Case Officer: Rebekah Morgan

Proposal: Reserved matters application to 19/01740/HYBRID - layout, scale, appearance and landscaping details for Phase 2 of the employment development (11,309sqm GIA) with associated landscaping and infrastructure works.

Drawing Title:
RM4 - Soft Landscape Proposals
(Sheet 1 of 4)

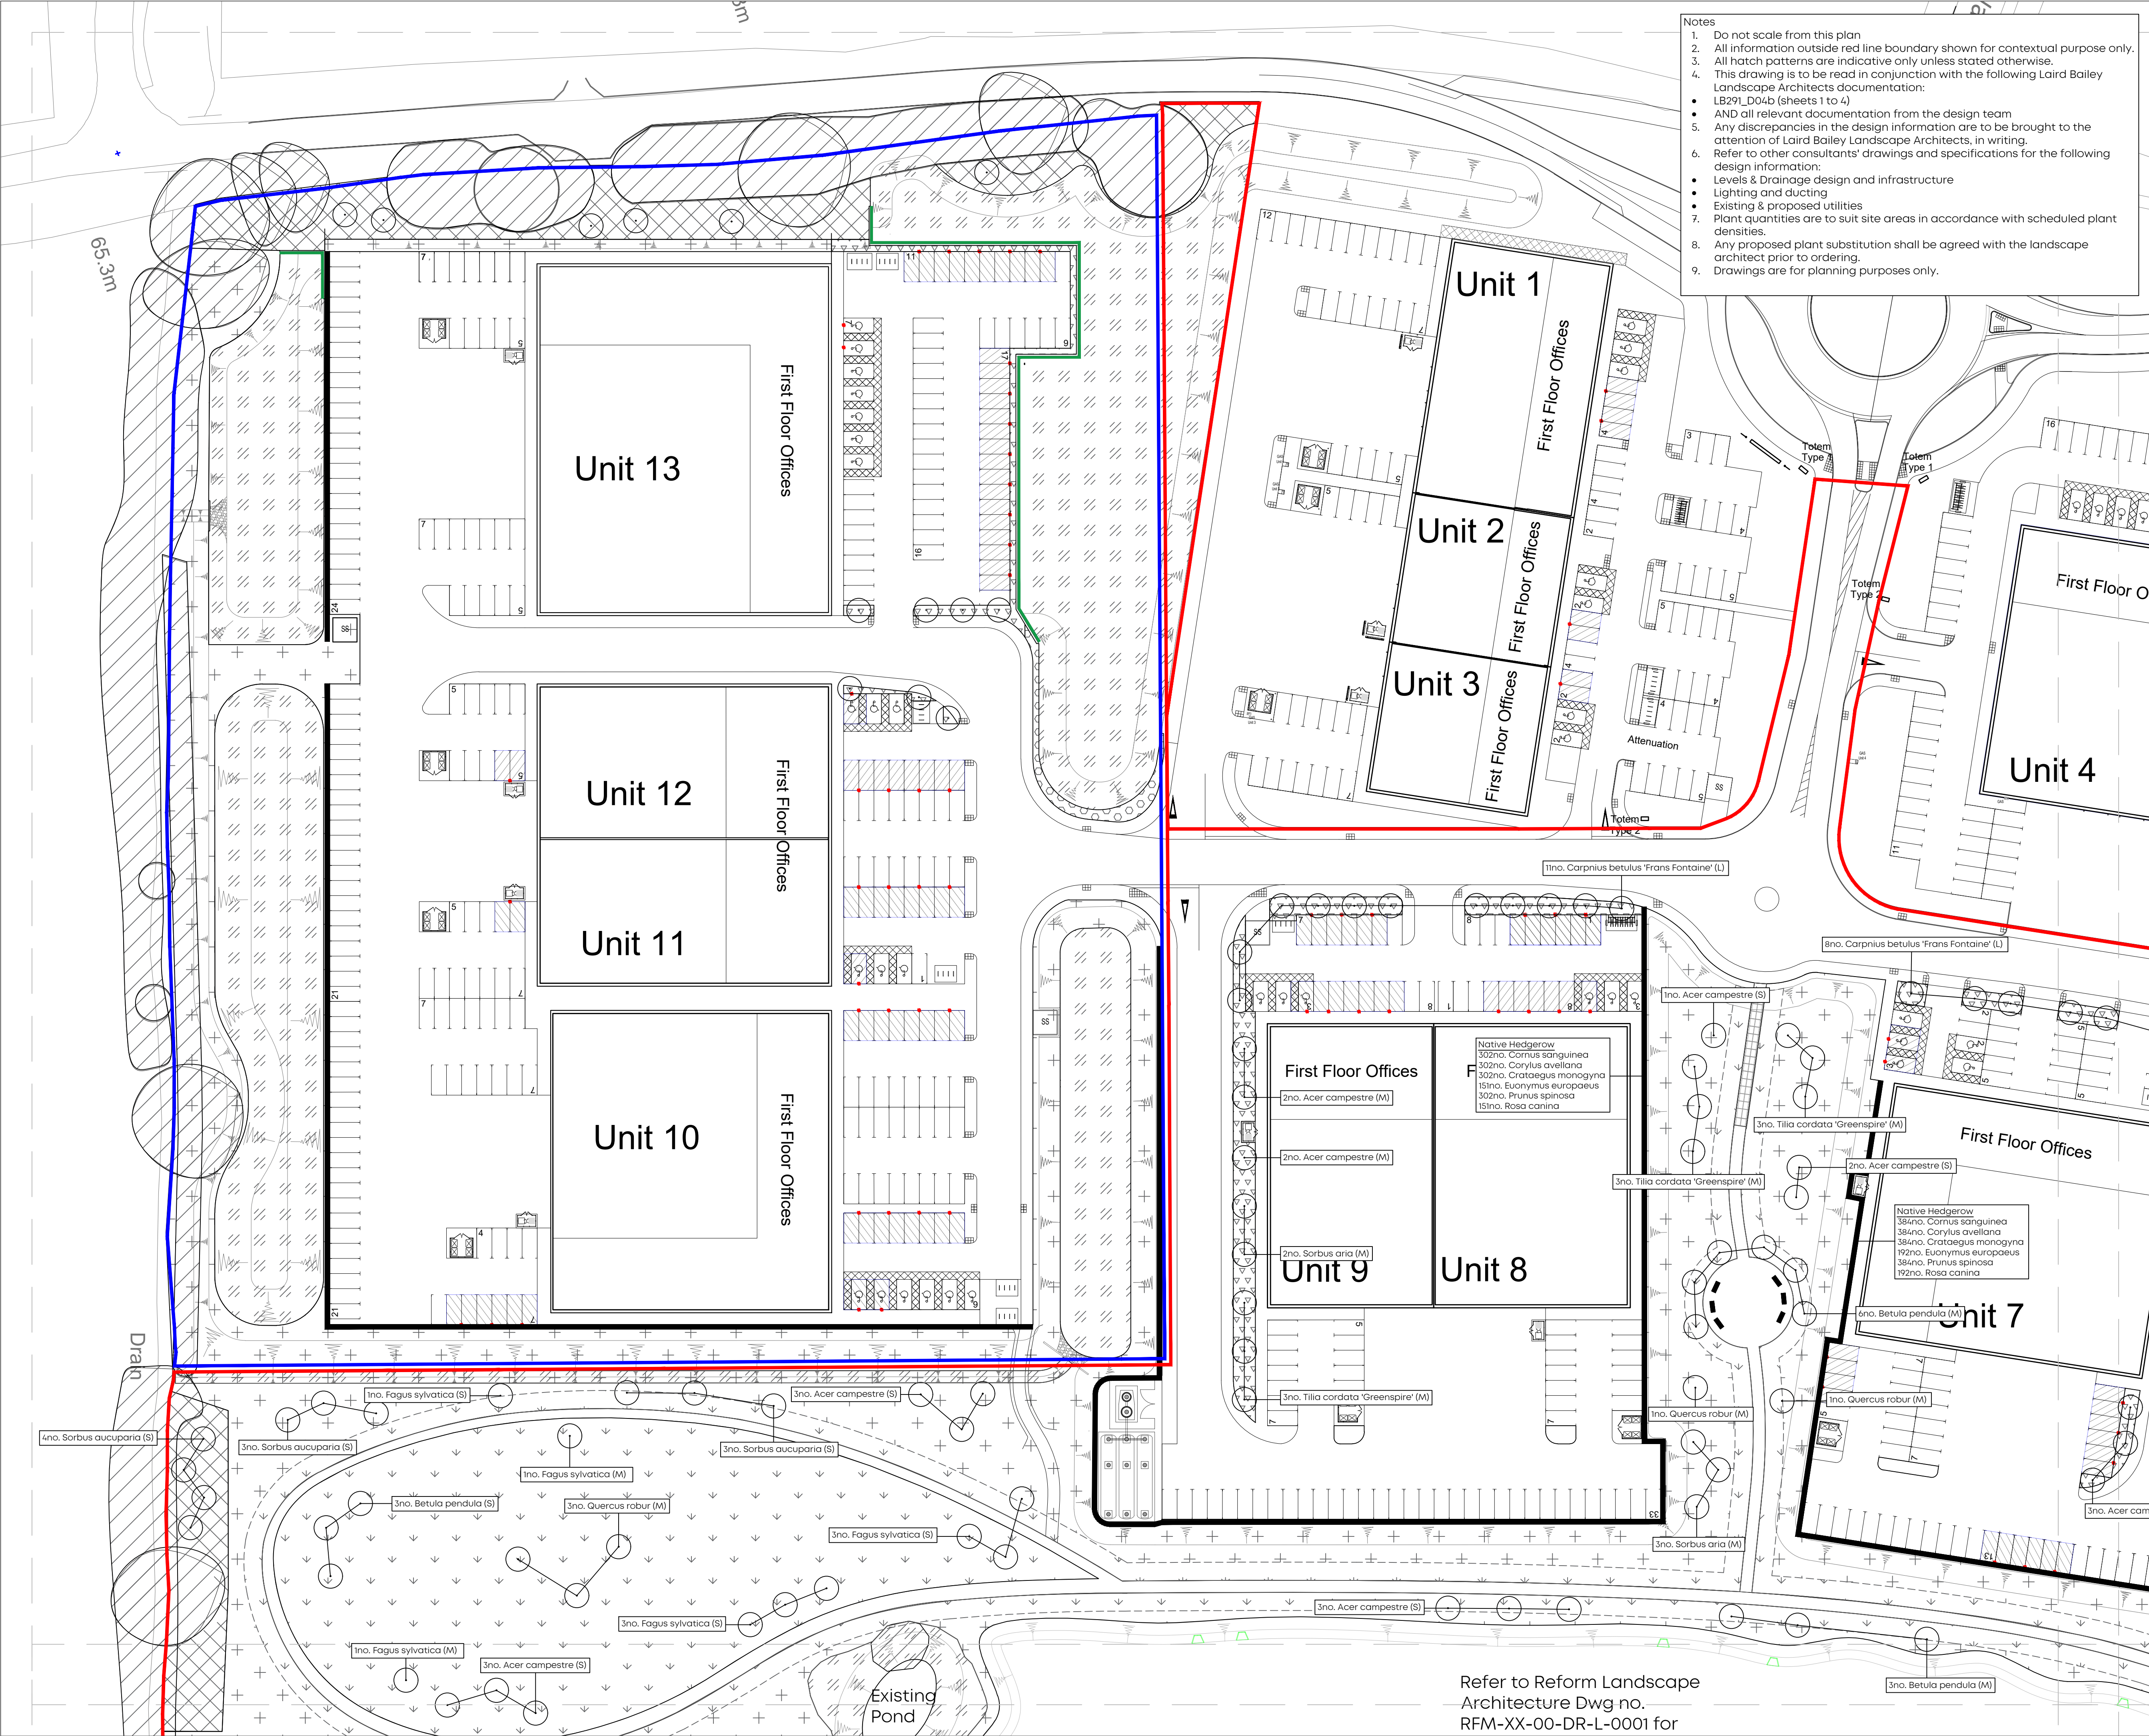
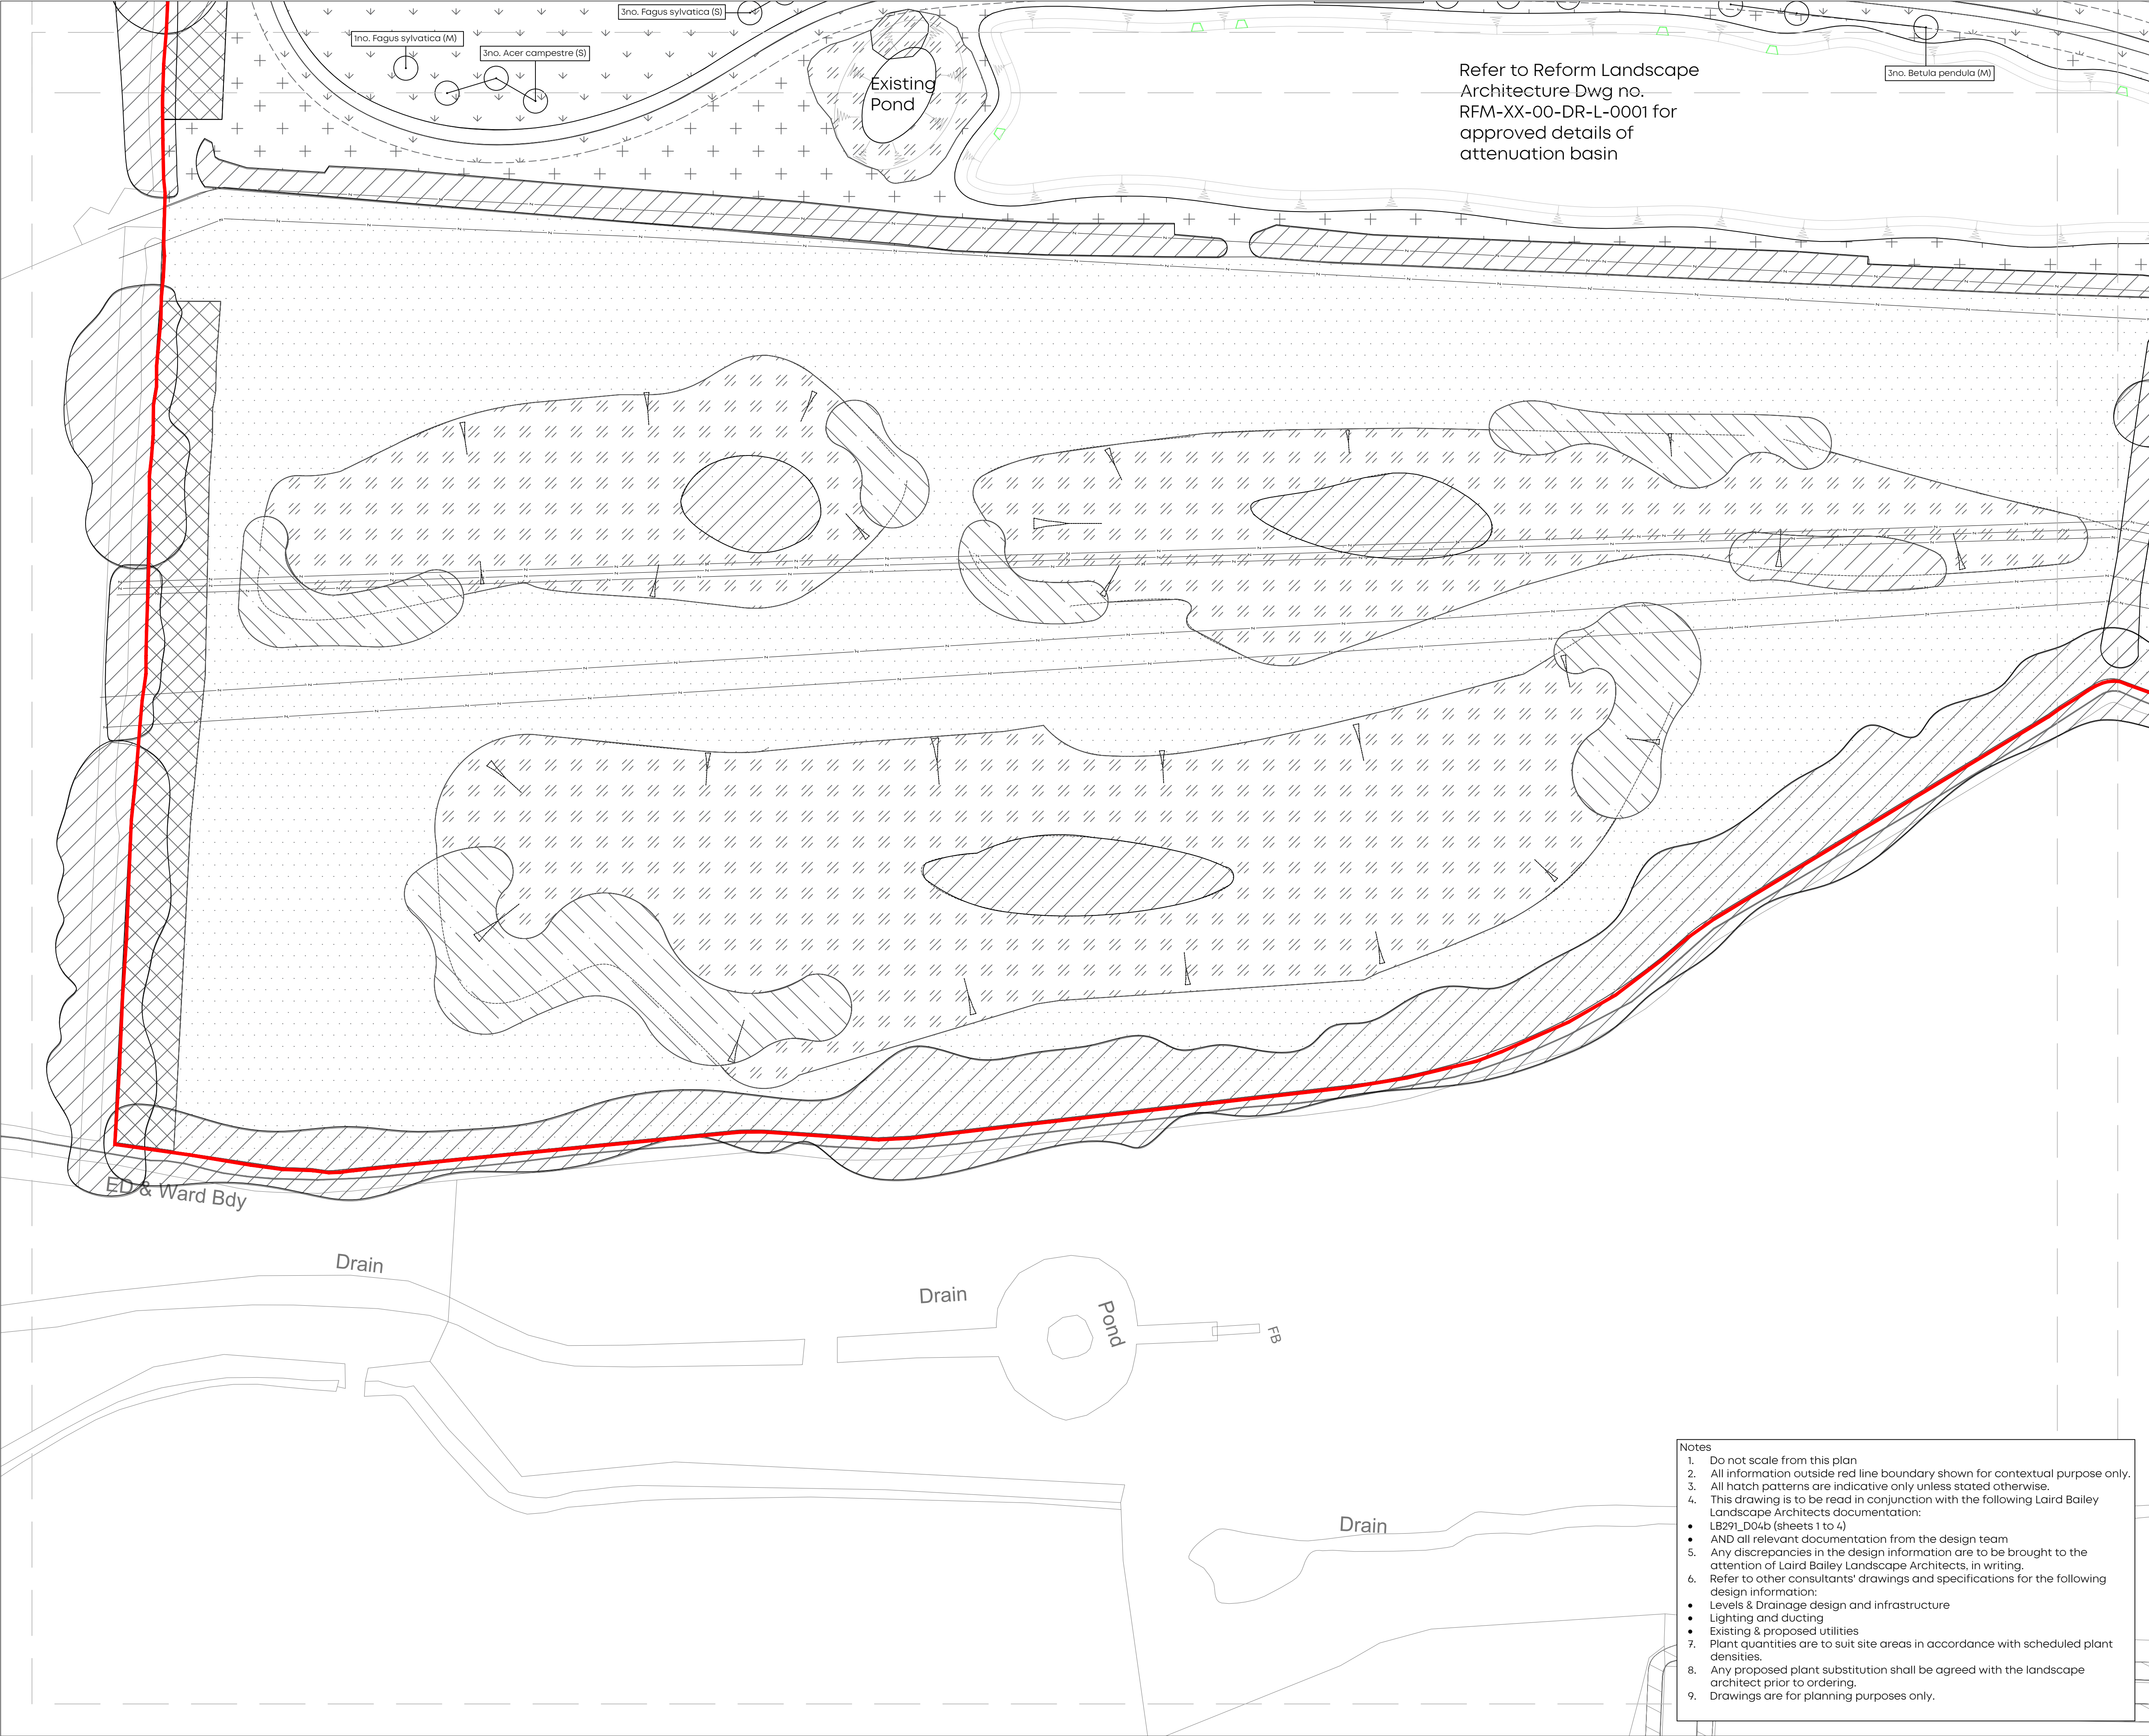
There is an opportunity to increase woodland on the site, which contributes towards carbon sequestration/offsetting of development's carbon release, visual mitigation, amenity for site users and wildlife habitat. Woodland areas, with species mixes, supplies sizes and planting densities are required - refer to marked up drawings. The 'oval' spaces east of units 10 and 5. Particular attention should be paid to ecological ecotone areas: the cross-over of habitats, woodland with woodland edge, woodland edge with herbaceous perennials against wildflower meadow – refer to marked up drawings enclosed.

Root flare must not be buried – refer the BS8545: 2014

Refer to item F. The CBR should not be increased by compaction methods. The aim is to ensure adequate drainage where moisture goes deep to encourage deeper root depth and tree stability.

Where there is plenty of space for canopies spread i.e., central greenspace between units 7 and 8, I would recommend native trees are planted for the habitat this provides for wildlife.

Lime Tilia cordata 'Green Spire' should be replaced with T. cordata

Trees planted close to paths and paved surface should be at least 2m away and a root deflector installed and indicated as such on the drawing.

- 8.20. The Council's Landscape Officer is broadly content with the overall landscaping scheme but did suggest that a larger quantity of trees could be provided. This has been noted, but it needs to be balanced with the drainage proposals and creating a safe/open environment for workers to use that has natural surveillance across the area. Therefore, the level of tree planting is considered to be appropriate.
